Application No: BR/286/20/HH
Site Address: 17 Shelley Road Bognor Regis PO21 2SL
Description of works: Removal of existing garage and erection of single storey side and rear extension

Thank you for your internet representation made on 9th December 2020 which has been recorded as an objection with the comments as follows:

Proposed

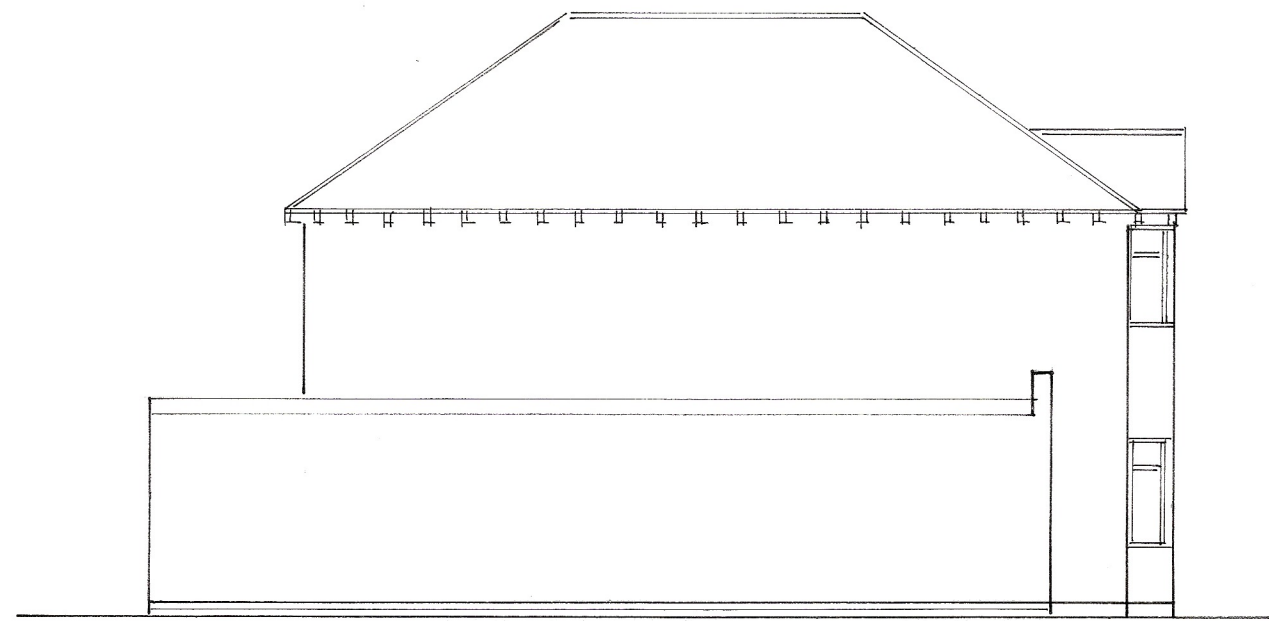
This dwelling will take my light away from my dining room and kitchen, the garage has a pitch at the moment, not a flat raised roof
